## Appeal Decision

**Appeal Ref: APP/C3810/W/17/3169745**

**1 Regis House, Richmond Road, Bognor Regis, West Sussex PO21 1BU**

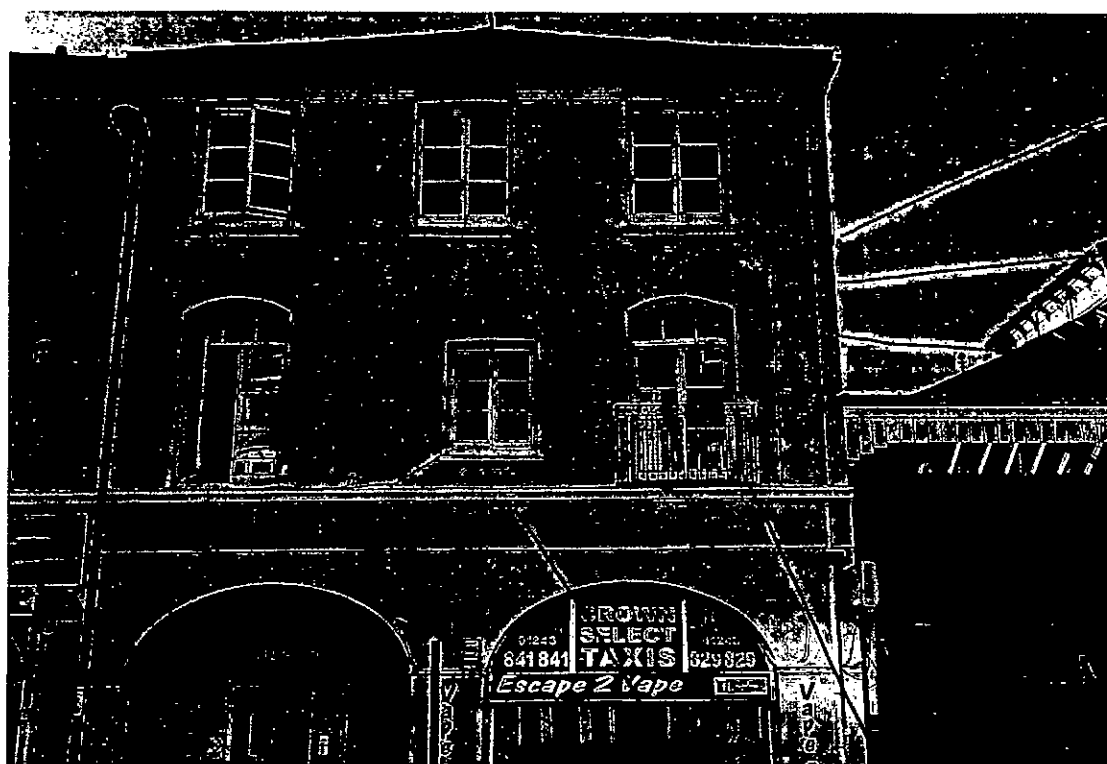
6. Flat 1 is on the first floor and has windows facing north west into the courtyard in front of the station, south east into Richmond Road and north east across the glazed canopy of the station. UPVC windows are thicker in frame and section than the existing windows and this would be particularly apparent when the windows are open. Moreover the appearance of the double glazed units would be very different to single glazing, or single glazing plus secondary glazing. The heritage significance of the existing building relies on its utilitarian history and former functional relationship with the adjacent station. Replacement of the windows facing south east would obviously contrast with all the other windows in this elevation, which appear to be original. Replacement of the windows in the north west elevation, although these are partially hidden, would contrast with the remaining timber windows on the second floor. I noted at the site visit that UPVC windows have been installed in the first floor Flat 3 facing the station forecourt and understand that this has been done without approval. These serve to demonstrate the difficulties that can be caused when heavy UPVC replaces the more delicate original painted timber sections.

8. The difficulties associated with replacement of original windows with matching facsimiles are understood, but once lost, heritage significance is very difficult to replace. The use of contemporary materials for replacement windows such as the Residence 9 type cannot be ruled out, but no drawings have been provided of the proposed elevations, sections or glazing. Without these, it would be impossible to have any assurance that the new windows would be sufficiently sympathetic. The replacement of windows on the south east and north west elevations with UPVC would not preserve or enhance the character or appearance of the Bognor Regis (Railway Station) Conservation Area and would diminish the setting of the listed building, conflicting with the heritage protection aims of policies GEN7 and AREA 2 of the Arun District Local Plan, policy 2 of the Bognor Regis 2015-2030 Neighbourhood Development Plan 2015 and the relevant aims of the National Planning Policy Framework.

9. However the windows facing north east are very difficult to see. The Council's Supplementary Planning Guidance on Conservation Areas published in 2000 provides helpful advice despite its age. It advises that permission will not normally be granted for replacement of traditional timber windows 'where visible'. The windows on the north eastern elevation are to all practical purposes, invisible from the public domain. Subject to conditions requiring details of the replacements, UPVC in this situation would not conflict with the policies above. I have imposed conditions requiring details of the replacement windows in order to ensure that they replicate as far as possible the existing sections and glazed areas.

1. The appeal is allowed in part and dismissed in part.
2. Planning permission is granted for replacement of windows on the north east elevation in accordance with the application ref BR/292/16/PL, dated 27 October 2016, subject to the following conditions:
  - 1) The development hereby permitted shall begin not later than 3 years from the date of this decision.
  - 2) Before any development begins, details of the head, sill, mullions, jambs and glazing of the replacement windows on the north east elevation at a scale of not less than 1:20 shall be submitted to the local planning authority and approved in writing. The development shall be carried out in accordance with the approved drawings.
3. The appeal is dismissed insofar as it relates to windows on the north west and south east elevations.
